From: Nicola Oktay on behalf of Planning.Responses
Sent: 07 August 2025 09:08
To: Planning Scanning
Subject: FW: Y/32/25/PL

Ecology and Biodiversity Net Gain response

From: Jonathan Best <Jonathan.Best@arun.gov.uk>
Sent: 05 August 2025 09:44
To: Planning.Responses <Planning.Responses@arun.gov.uk>
Cc: Simon Davis <Simon.Davis@arun.gov.uk>
Subject: Y/32/25/PL

Land West of Bilsham Road Yapton BN18 0LA.

Figure 3.1: UK Habitat Plan – post development

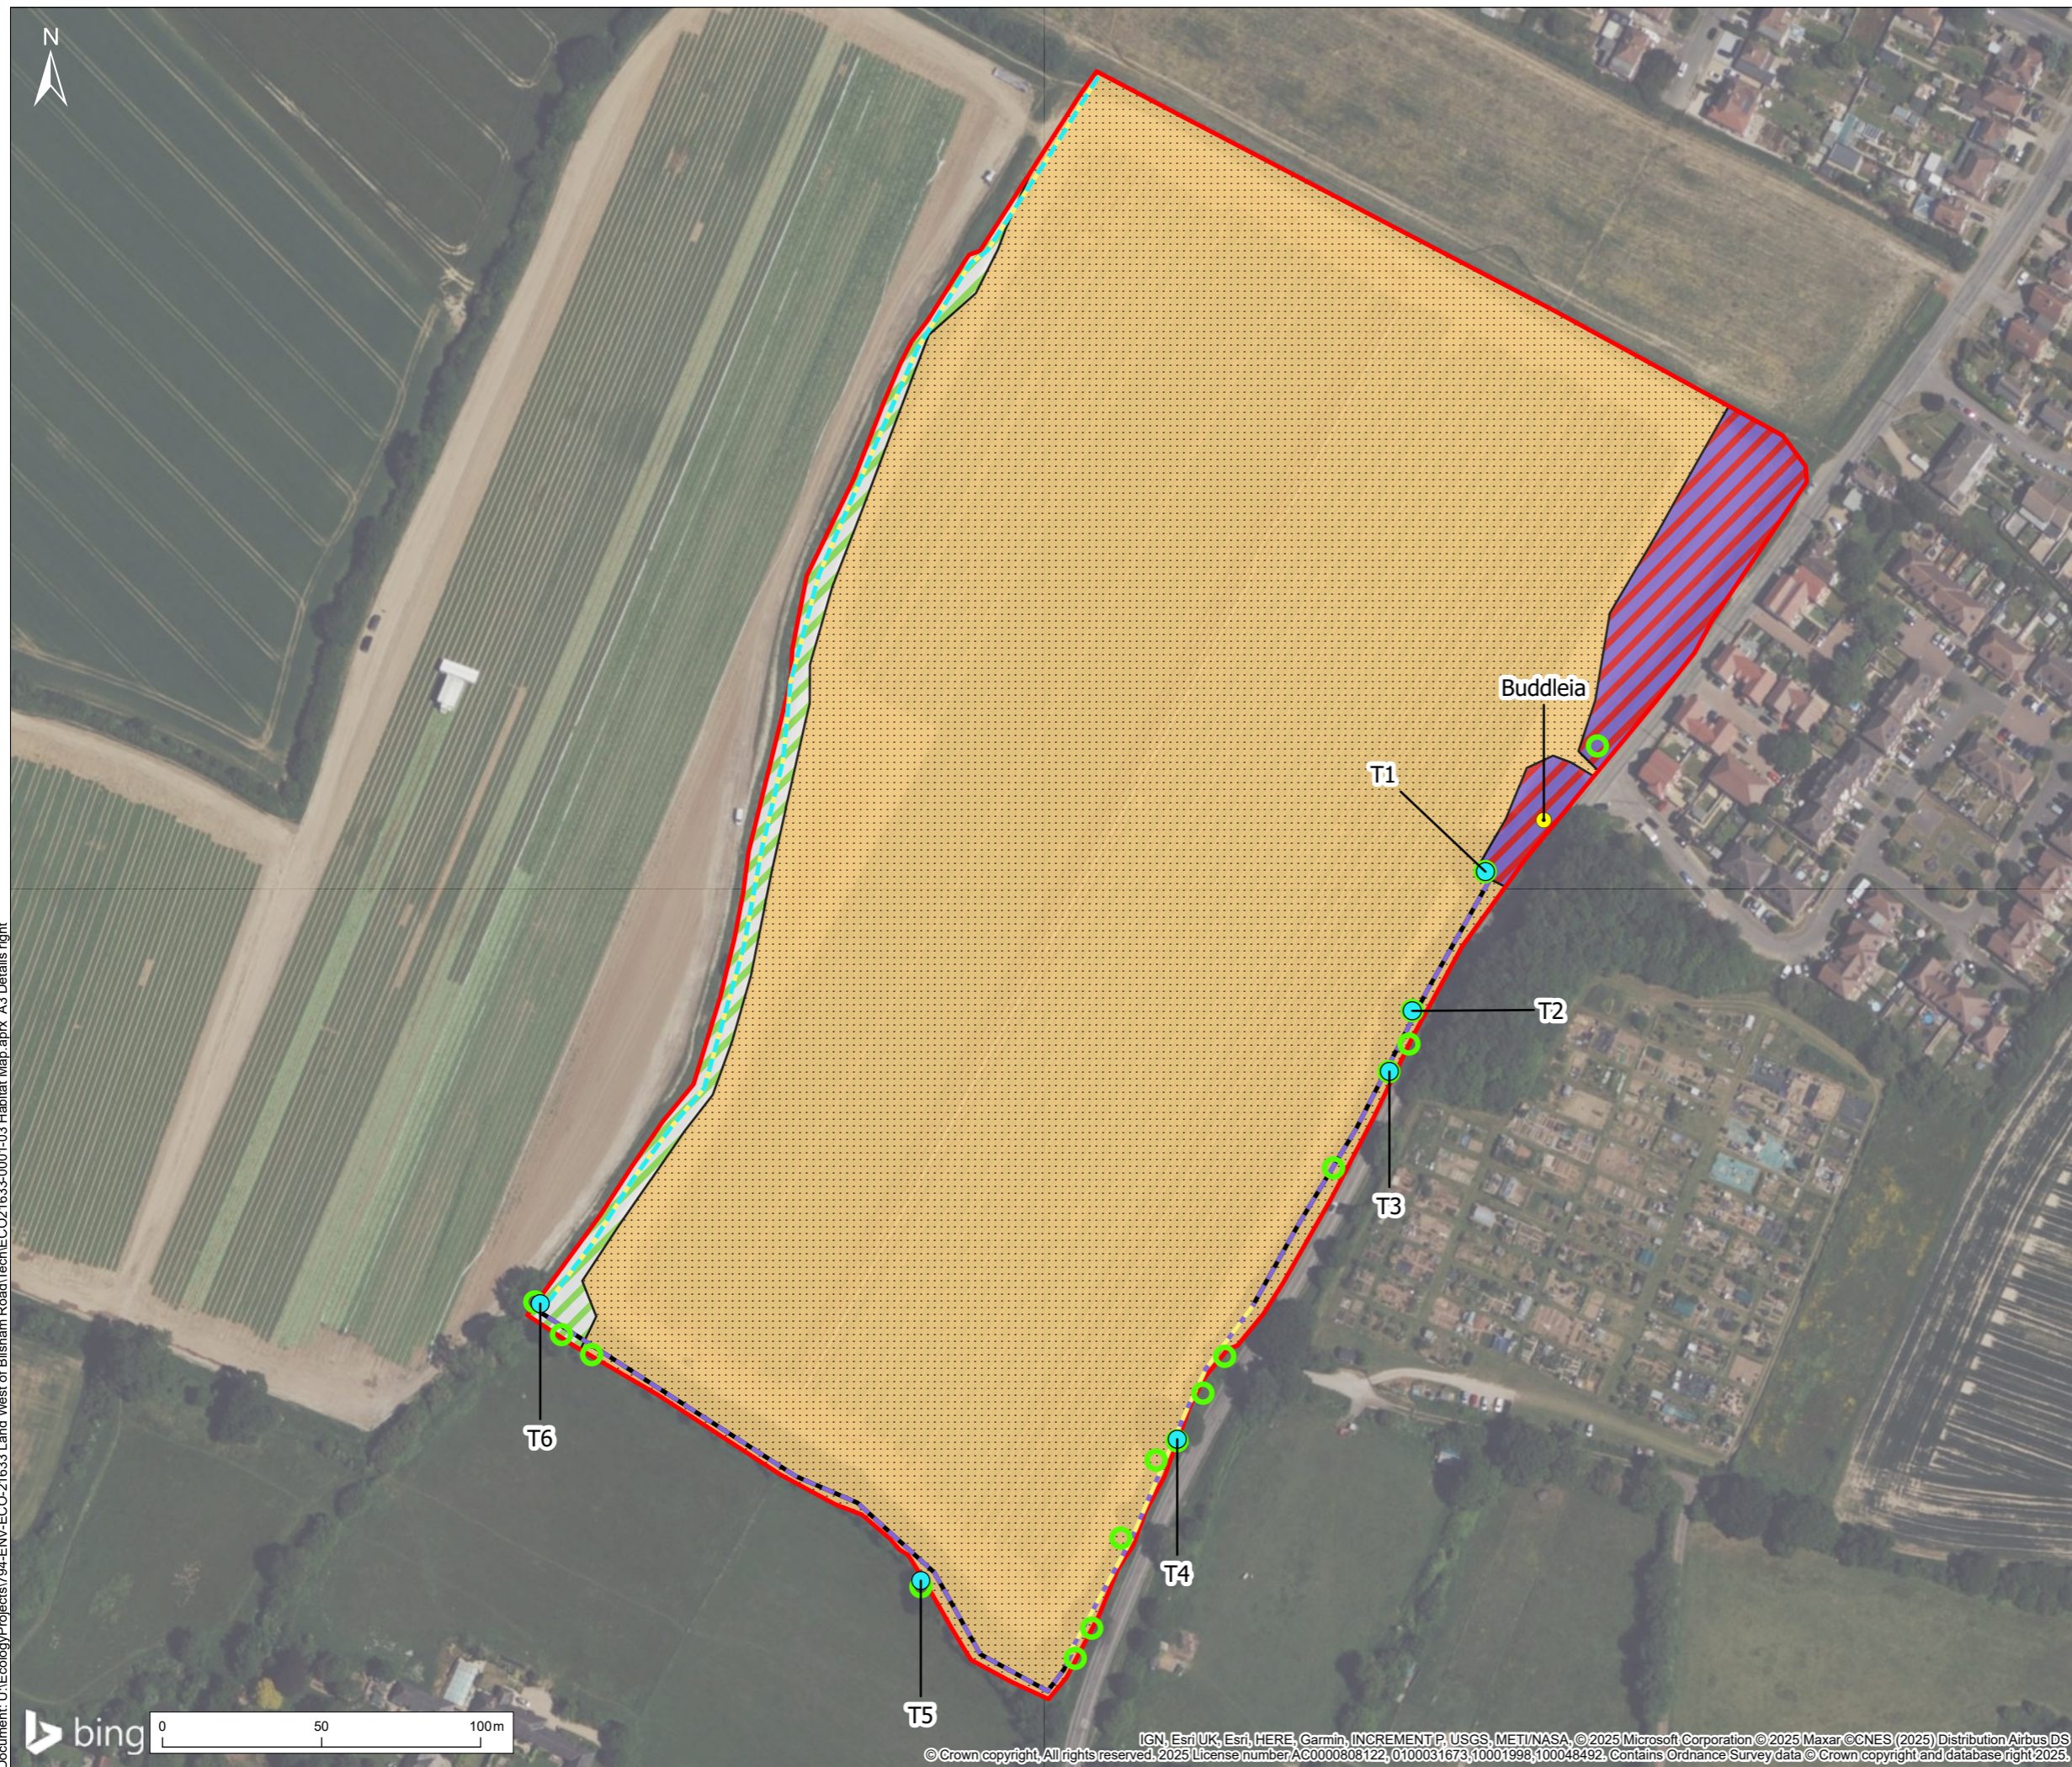
The BNG assessment report dated July 2025 refers to figures from the previous Metric submitted on the 2nd May 2025 also dated the 1st May 2025. This is confusing and the BNG post development habitat plan within the report may need updating as I am unclear which metric it relates to.
